Re: PA22-023- Brodie Rezone PRD – Technical Review 2

SUBJECT: PA 22-023 – Brodie Subdivision

ROAD A
 HOR: 1"=40'
 VER: 1"=4'

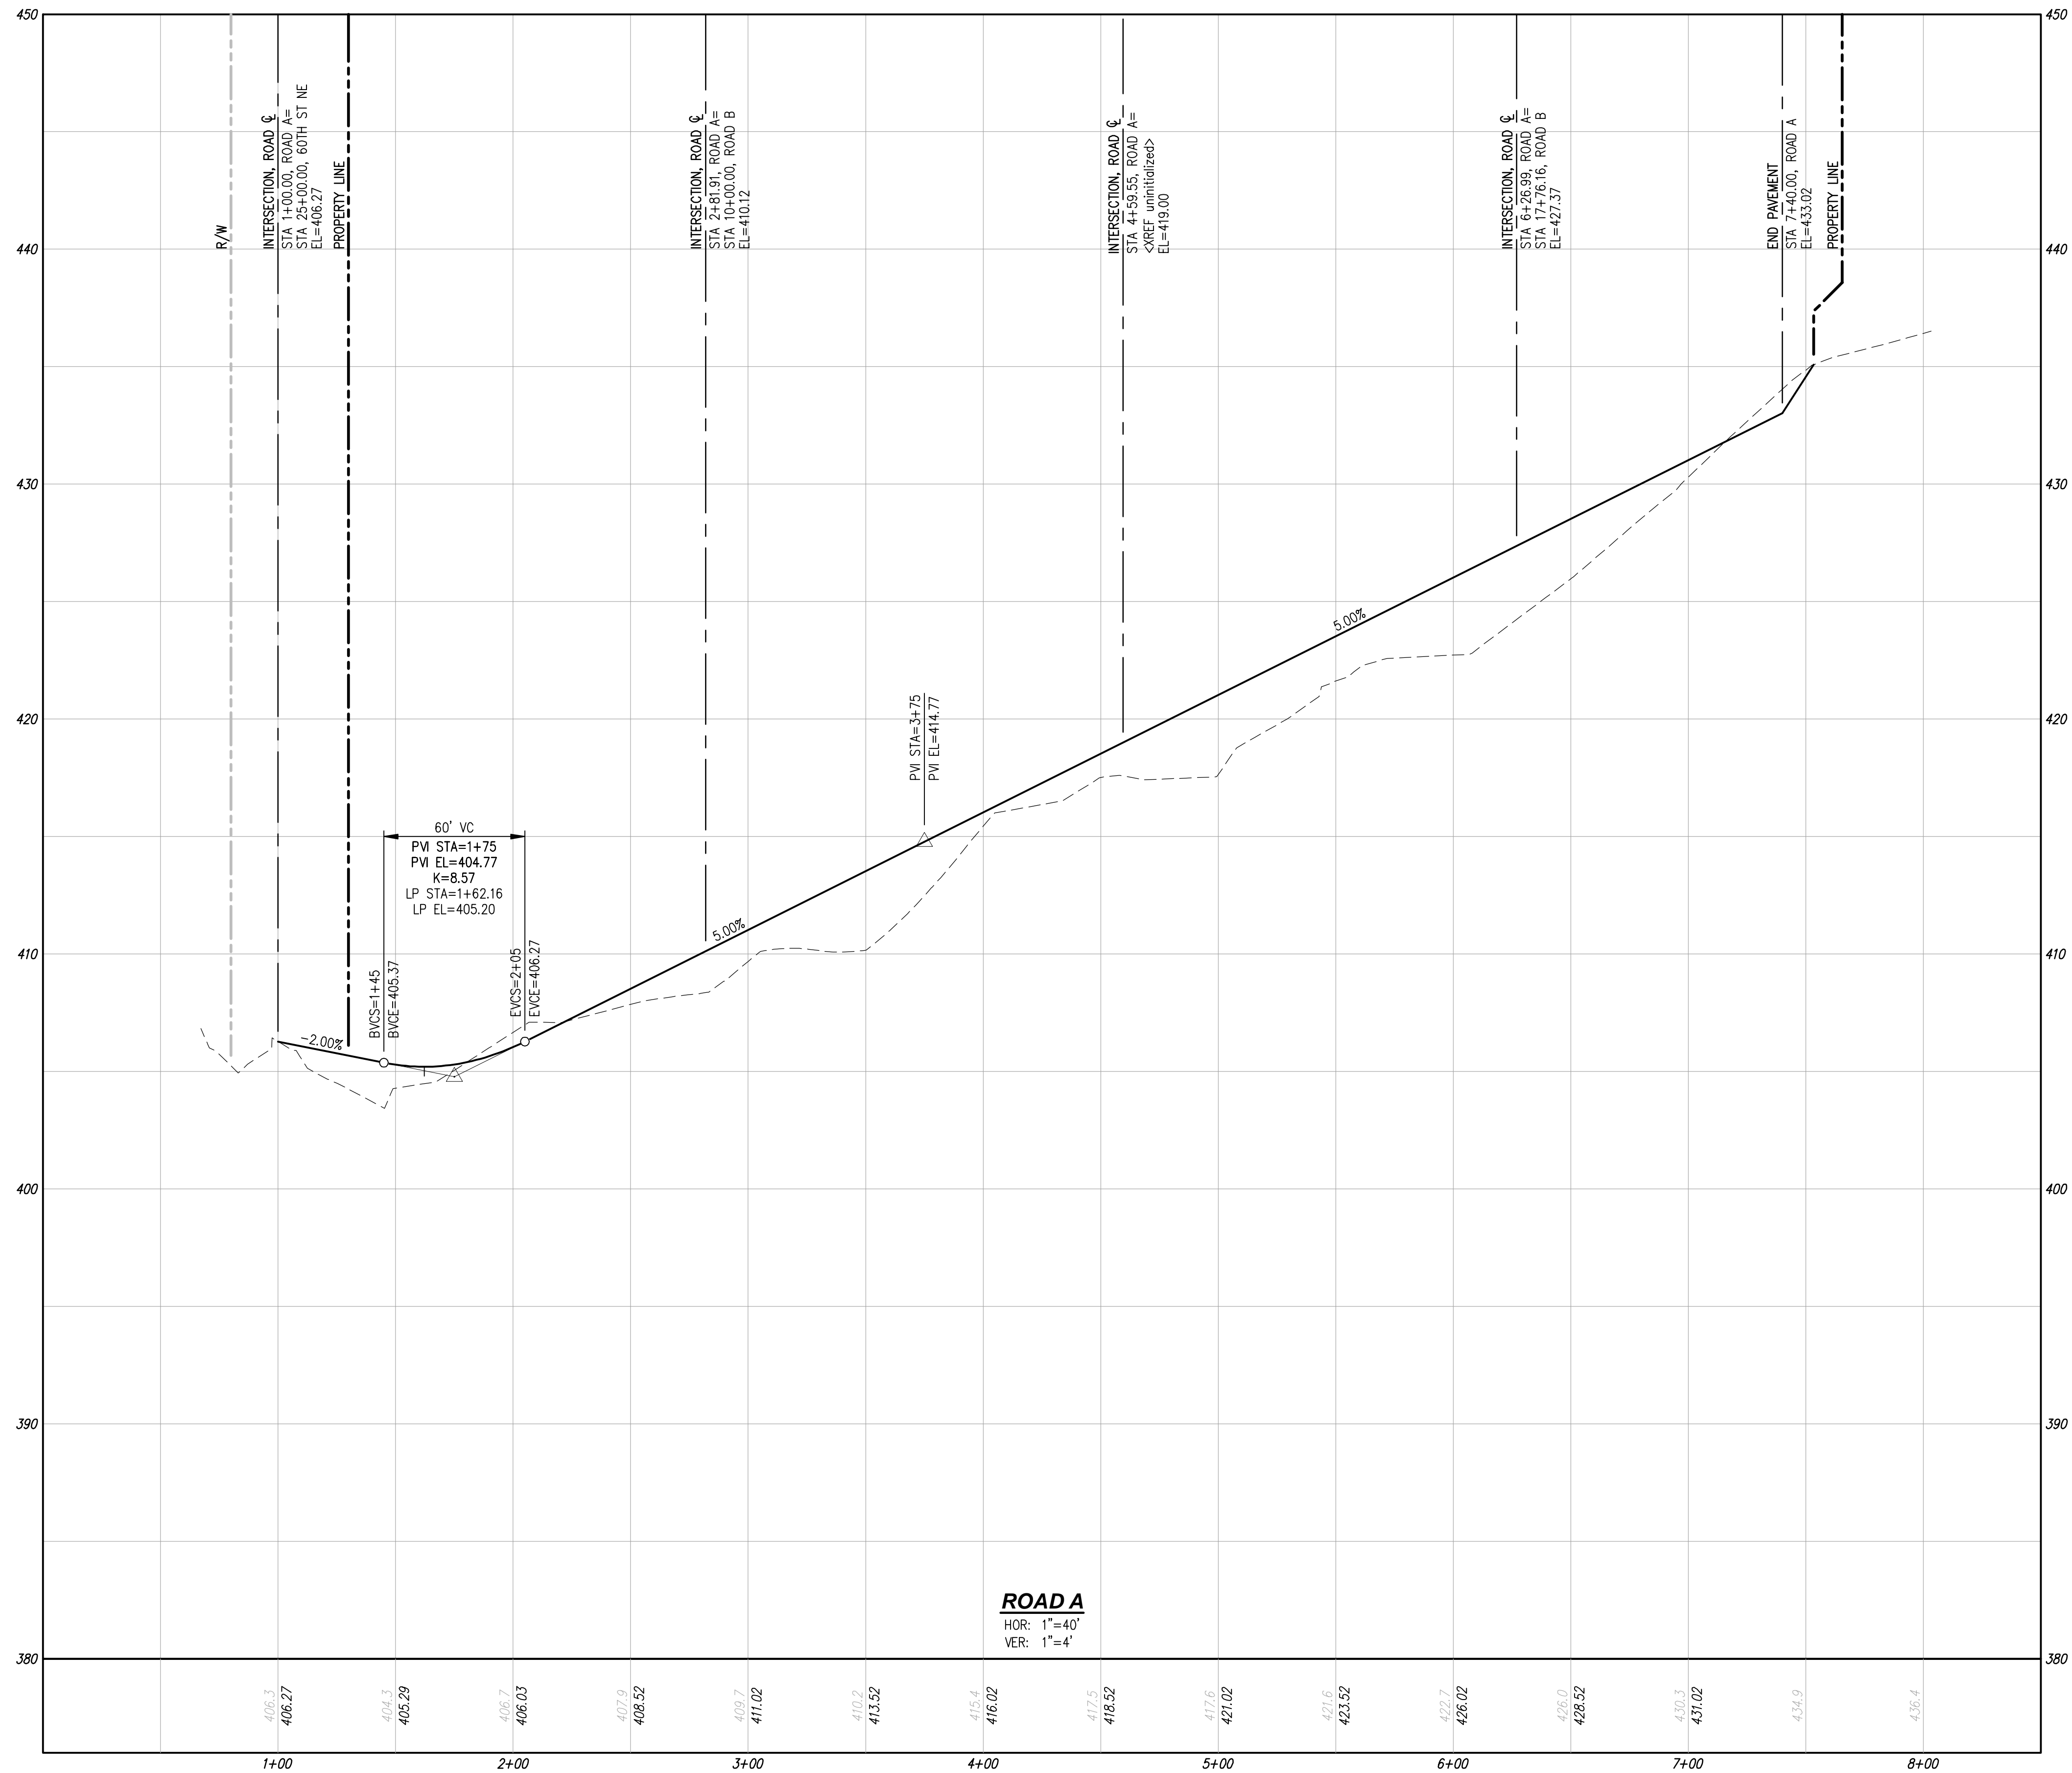
- i. Residential street(s) shall be designed as collector arterial utilizing 100 watt equivalent LED fixtures.
 - ii. Spacing of fixtures should be approximately 180'-220'.

1. Approximate Street Light locations upon Road B:
 - a. STA 10+75
 - b. STA 12+75
 - c. STA 14+75
 - d. STA 16+75
 - iv. Snohomish County PUD Process:
 1. For residential plats, contact PUD Plats via email at plats@snopud.com and include a PUD Plats application to begin Snohomish PUD process.

- 3) A signing and channelization plan shall be required as part of civil construction plans.
 - a. Signing:
 - i. Stop sign with street name signs upon SB approach of Road A to 60th ST NE.
 - ii. No Outlet sign upon Road A north of 60th ST NE.
 - iii. Street name signs at all intersections and 90 degree roadway curves.
 - iv. No parking (symbol) with arrow signs on either side of alley entrance/exits to enable emergency vehicle and garbage collection access.
 - v. No parking (symbol) with arrow signs on outside or 90 degree curves, 15'-20' prior to and after 90 degree curve to enable garbage collection access.
 - vi. Type IV Object Markers centered in each of NB/SB lanes at roadway end with Future Roadway connection sign upon centerline.
 1. Barricades shall not be approved/installed.
